**Planning Department  
Transportation Development Services**

September 26, 2014

**Re: Philip Lovato & Sons, 4101 4<sup>th</sup> St NW**  
**180-Day Temporary Certificate of Occupancy-Transportation Development**  
Engineer's Stamp dated 07-06-14 (G14-D085)  
Certification dated 09-22-14

TRAFFIC CIRCULATION LAYOUT
APPROVED
Signed: [Signature]
Date: 7/16/14

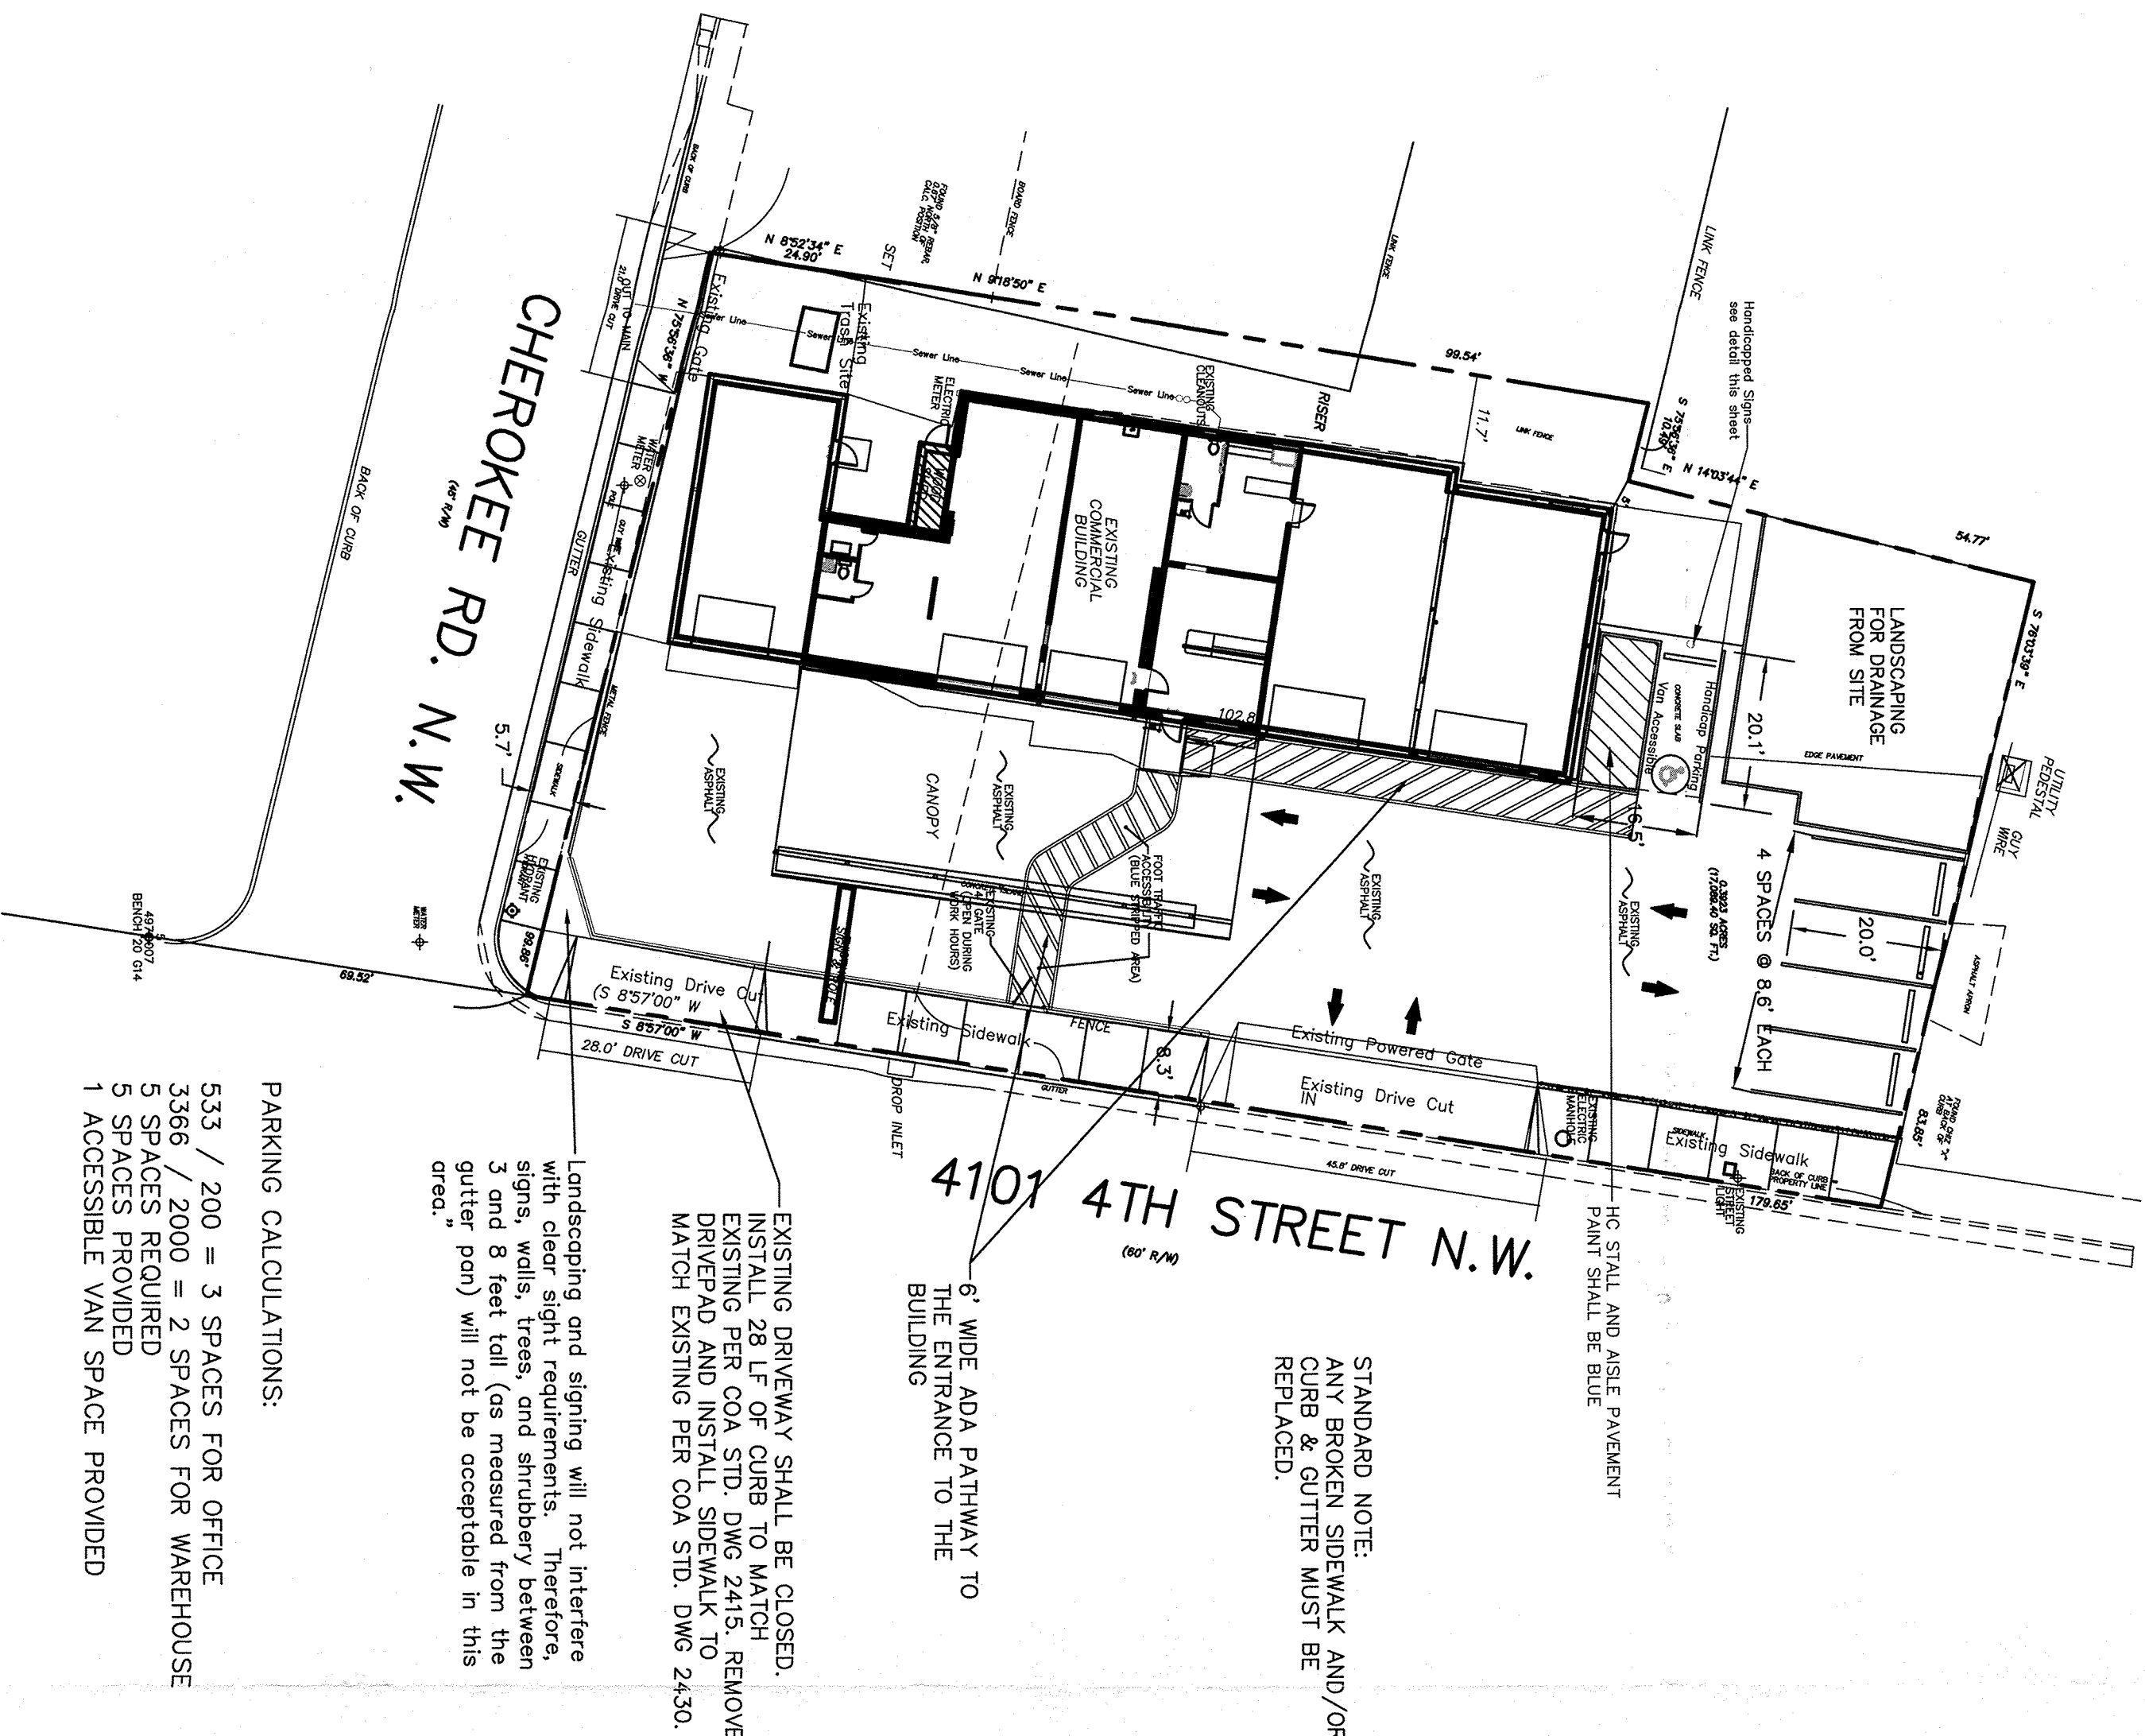
- The 28' driveway located on 4<sup>th</sup> street at the SW corner of the site needs to be closed and replaced with standard curb, gutter and sidewalk.
- Remove bollards located in the public right of way at the SW corner of the site and install truncated domes on the corner ramp.
- Ensure that the dumpster is in the location shown on the site plan.
